From: Maria Tomalova
Sent: 13 August 2021 10:48
To: Laura Bourke [REDACTED]
Subject: RE: Y/88/21/DOC

Subject: Y/88/21/DOC

Please see below the comments of our Drainage Officer.

Condition 5

SITE LAYOUT
(1:200)

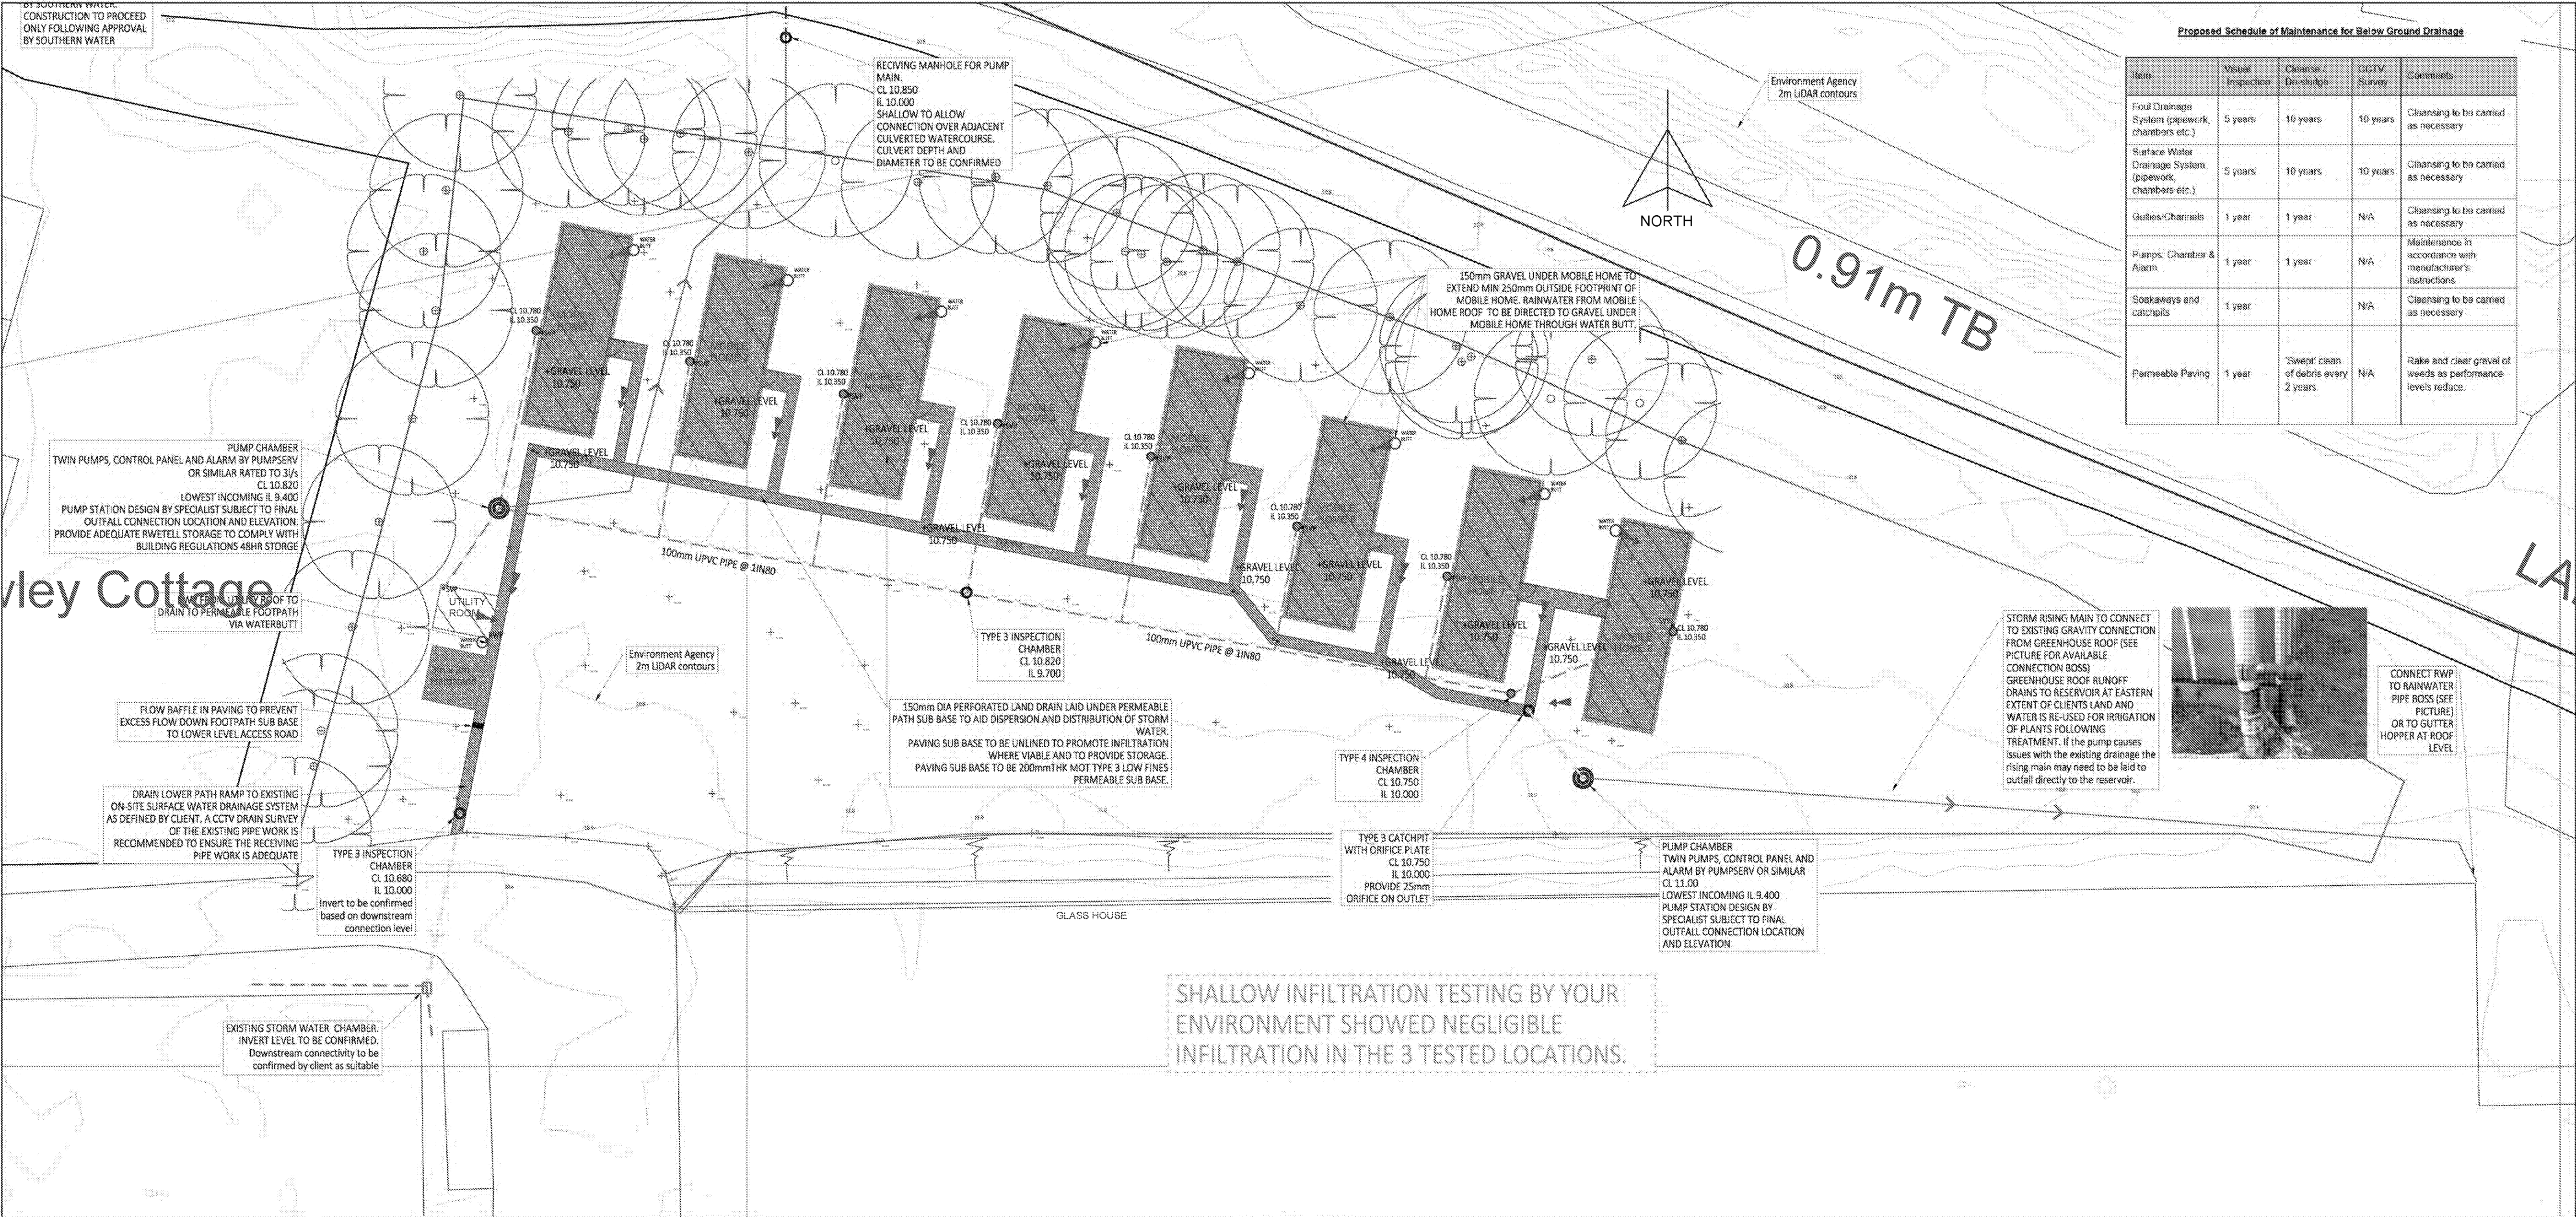
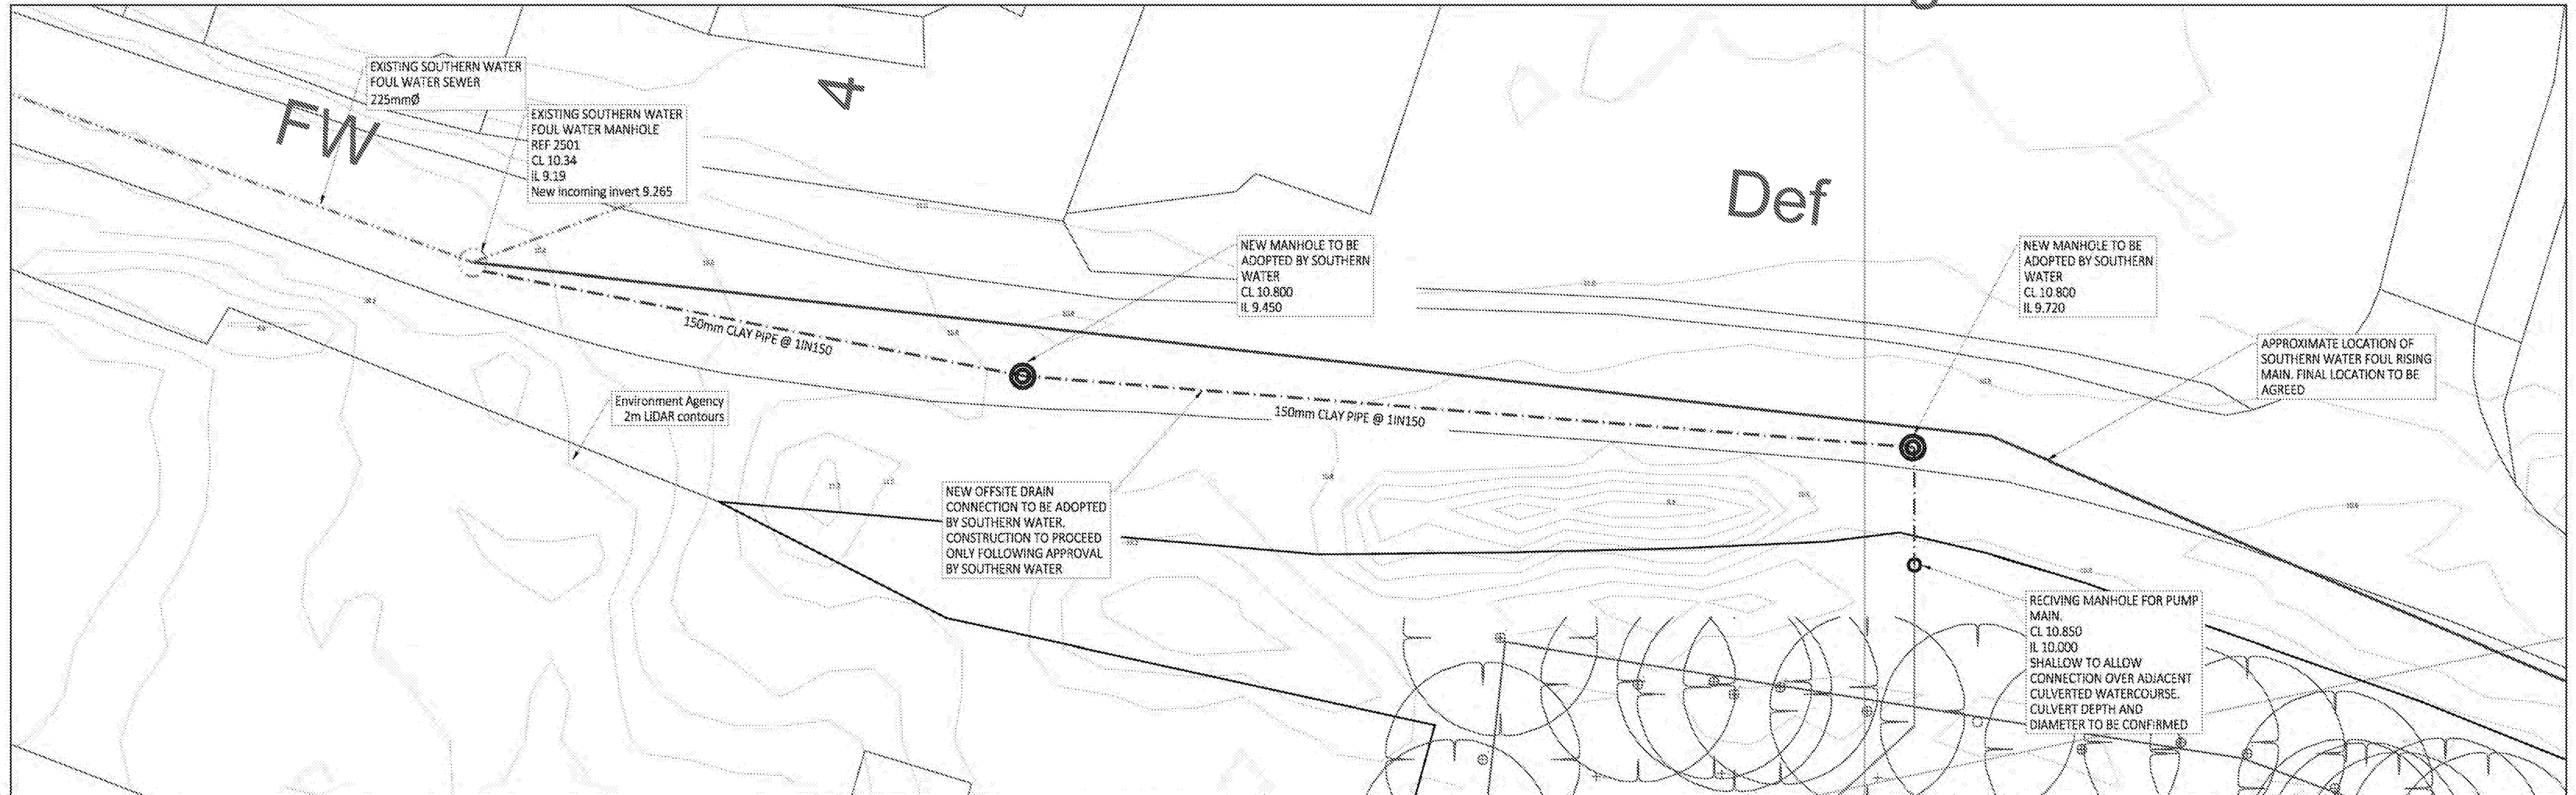
1. The applicant has completed summer infiltration testing which indicate infiltration is not viable.
2. No winter groundwater monitoring results have been provided, this information must be supplied to evidence that groundwater will not get into the surface water drainage system.

3. The proposal is for an unlined system to be pumped. This could in winter result in groundwater being pumped.
4. Pumping is not supported, it is not a sustainable solution. Pumps also fail and can result in increased flood risk both on and off site. The applicant must submit a revised gravity scheme.

5. The proposals are to pump surface water to the on site reservoir. The statement claims that no surface water will be discharged off site. No evidence has been submitted to evidence that either the existing surface water drainage network or reservoir have the capacity to accept these additional flows. The reservoir must also have an overflow to somewhere for water to be discharged in times of exceptional rainfall when irrigation demands are less, i.e. the winter. Therefore the statements provided are not supported by ourselves.

It is not possible for us to recommend discharge of this condition at this time with the strategy presented. A fully revised surface water drainage design is required, which may involve a gravity outfall to watercourse.
